Job No. 185466

August 8, 2022

Re: Response to:  
Colorado Geological Survey Review Comments, dated June 6, 2022 and  
El Paso County Planning and Community Development Comments, dated June 1, 2017.

RMG - Rocky Mountain Group prepared the "*Soils and Geology Study*" (RMG Job No. 185466, amended August 8 2022) for the proposed minor subdivision to comprise three single-family residential lots on approximately 61.55 acres. The report was reviewed by personnel of the Colorado Geological Survey (CGS). The purpose of this letter is to provide our response to the CGS and El Paso County Planning & Community Development review comments. The responses and modifications noted herein have been incorporated into our amended report.

FIG No. 4

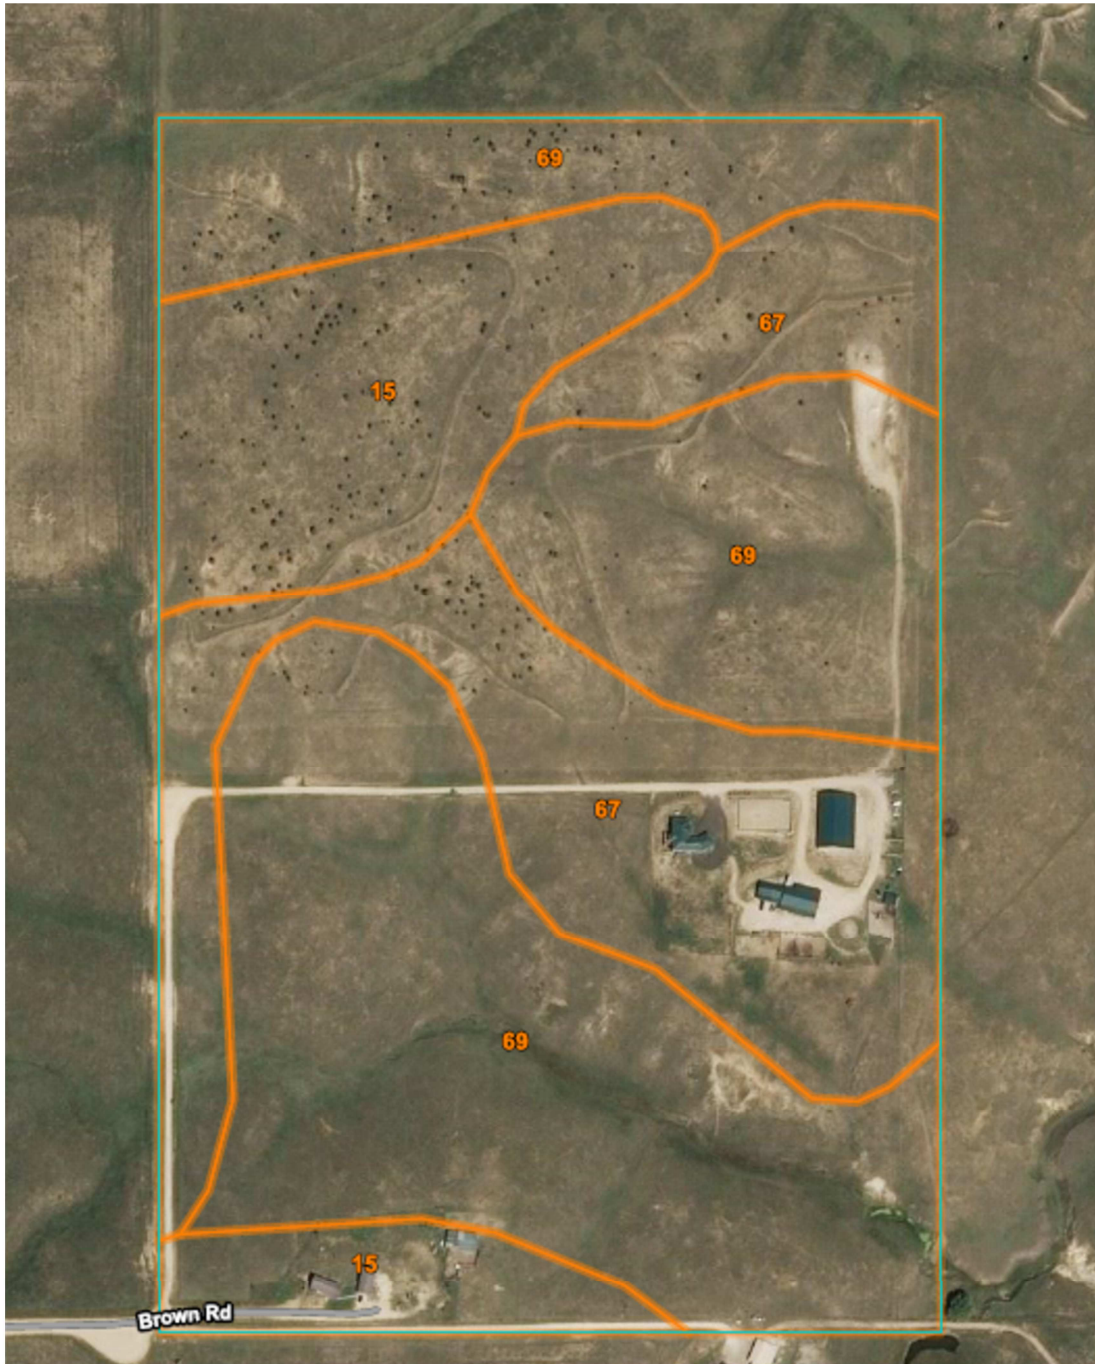
Test pits described on Pg 6 need additional information per Engineering Criteria Manual Appendix C for Geologic Report guidelines Section C.2.2.6

- The Test Pits locations are included on Figure 5 of the amended report. The Test Pit Logs, Figure 4 have also been included.

FIG No. 5

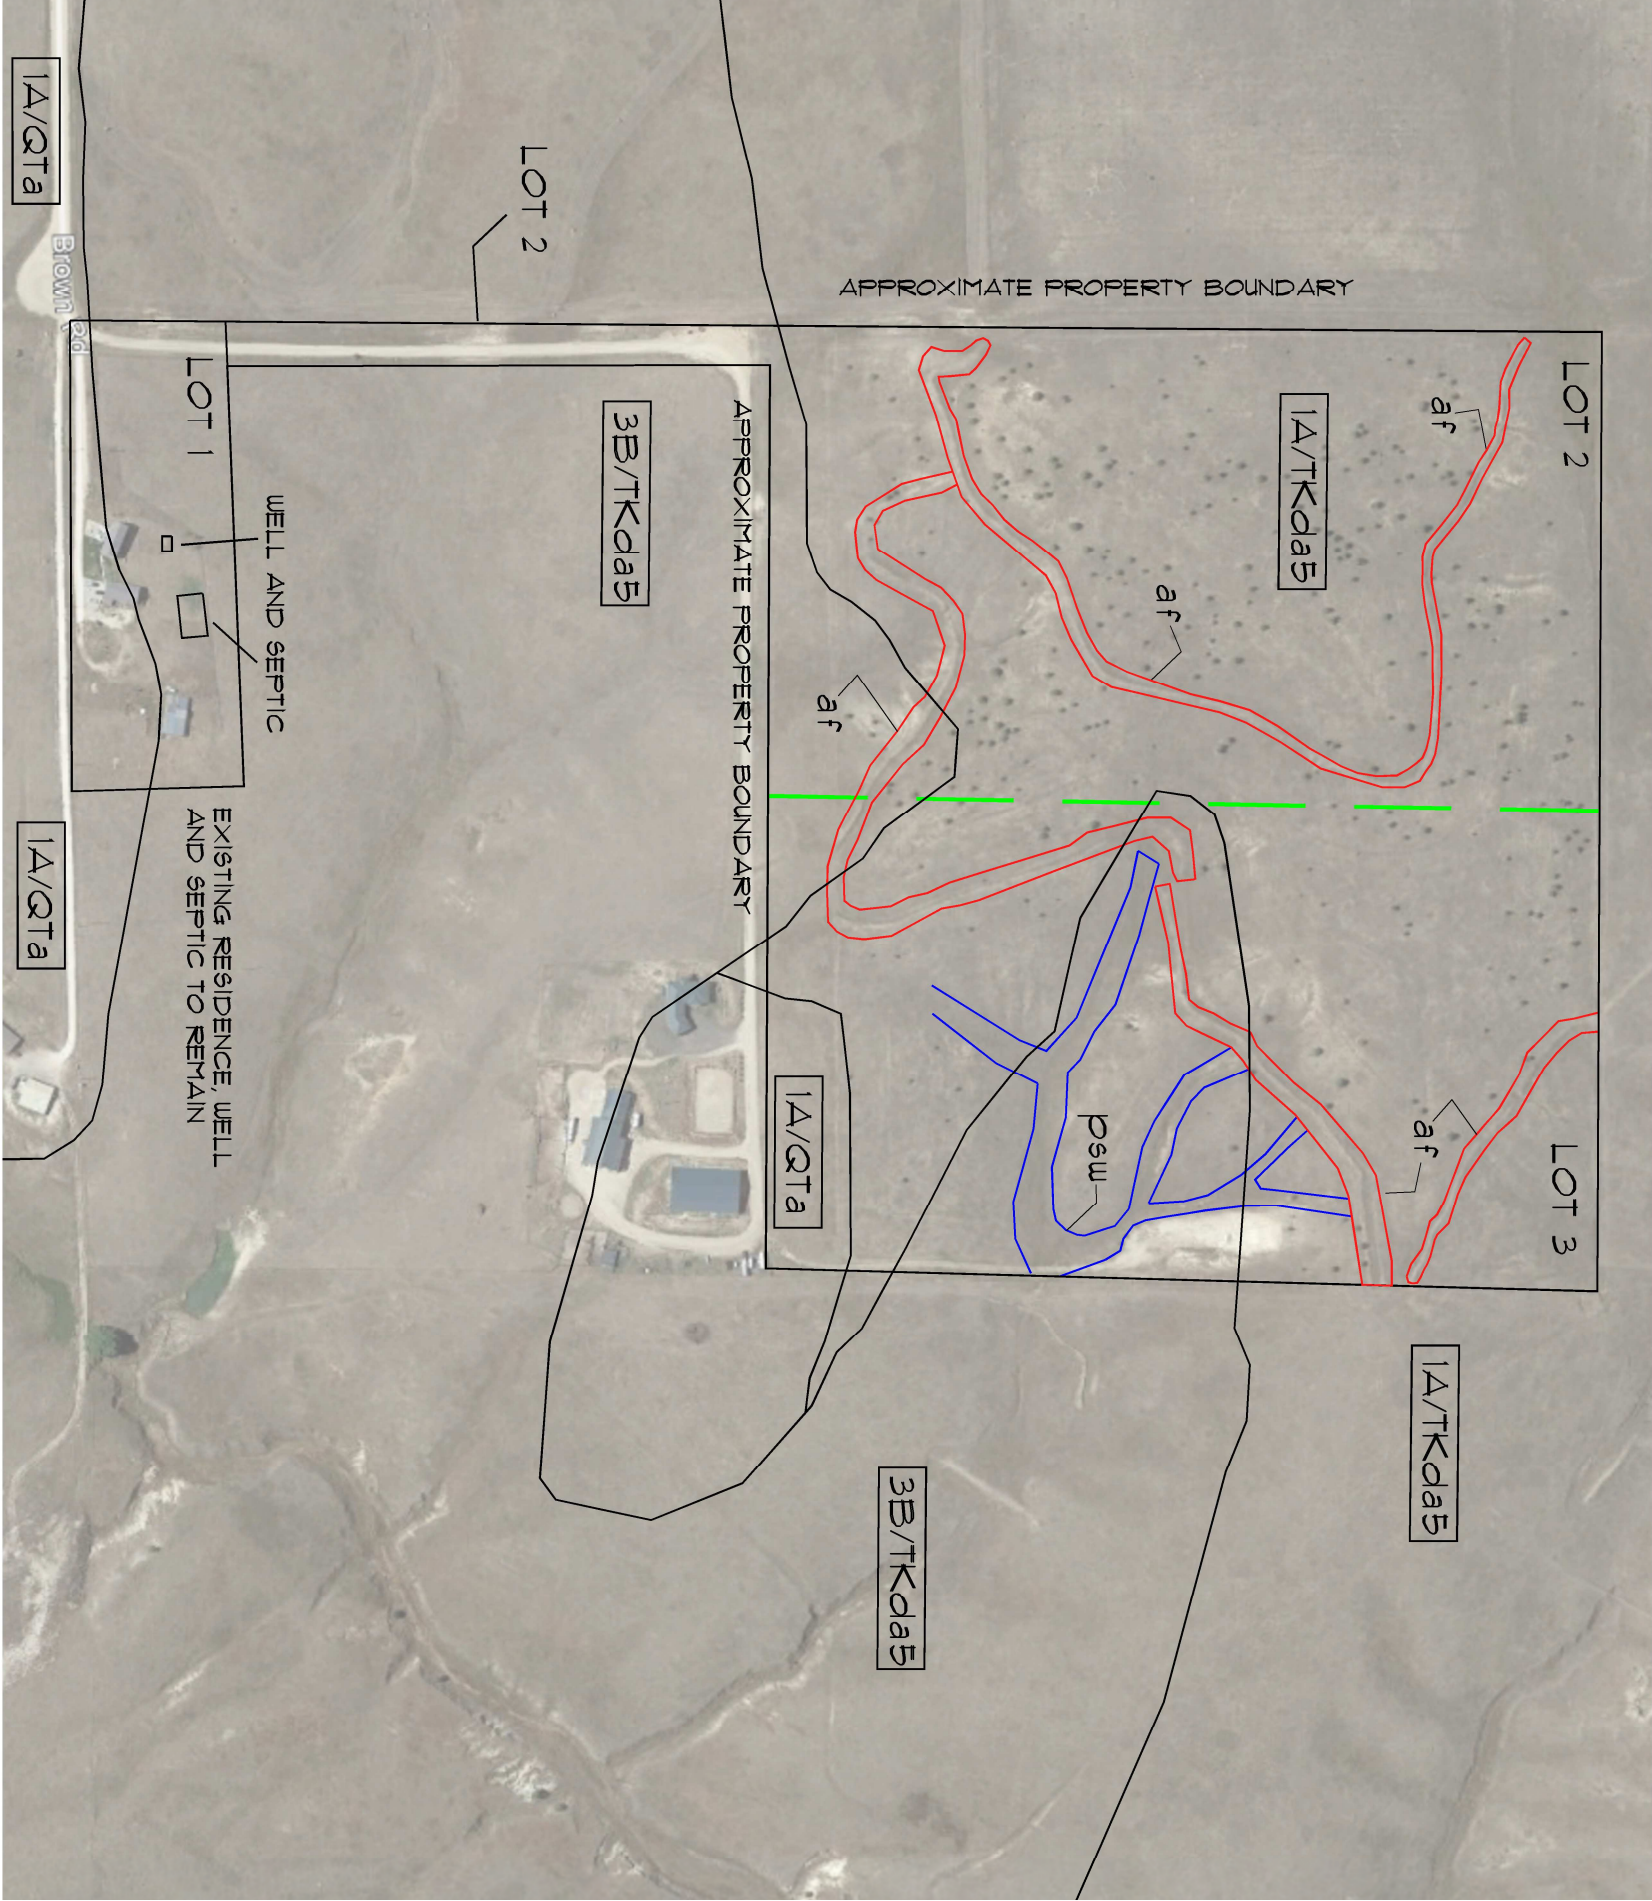
depths where both are likely to be shallow. The Engineering and Geology Map (figure 4) also designates areas within lot 3 as "potentially seasonally wet area." Mitigation measures for this hazard/constraint are not included in RMG's report. The expanded report should also include a discussion on groundwater conditions. If shallow groundwater is encountered or expected based on the subsurface conditions, the report should discuss the expected seasonal groundwater fluctuation expected at the site based on site-specific data and the feasibility of basements or other anticipated habitable below-grade space.

See CGS review comments to be addressed on seasonal wet areas on Fig 4 and expected seasonal groundwater fluctuations etc. The drainage report depicts a proposed building site potentially directly in the area shown as season wet area.

Test Pits and Trenches. The test pit and trench information shall: • Describe the location and dimensions of all pits and trenches and date of investigation; • Indicate the location of all excavations on the topographic/geologic map and profiles; • Provide a large scale descriptive log with sufficient detail; and, • Show sample location if supplemental laboratory tests were conducted.

- The CGS comments have been addressed in our responses above and in the amended report.
- The Drainage Report is outside the scope of the Soils and Geology Study. The Owl Ridge Subdivision, Final Drainage Report, last dated March, 2022 prepared by SMH Consultants, Figure 4, shows the proposed building location for Lot 3, approximately 7,000 SF between the seasonally wet areas, as mapped by RMG. At this time, construction is not proposed on Lot 3. However, if construction is proposed in the future, a site specific subsurface soil investigation is recommended to verify the depth of groundwater. It is recommended that future structures be located outside any potentially seasonally wet areas.

- The Test Pits Logs are included on Figure 5 of the amended report.
- The test pit locations are indicated on the Engineering and Geology Map, Figure 5.
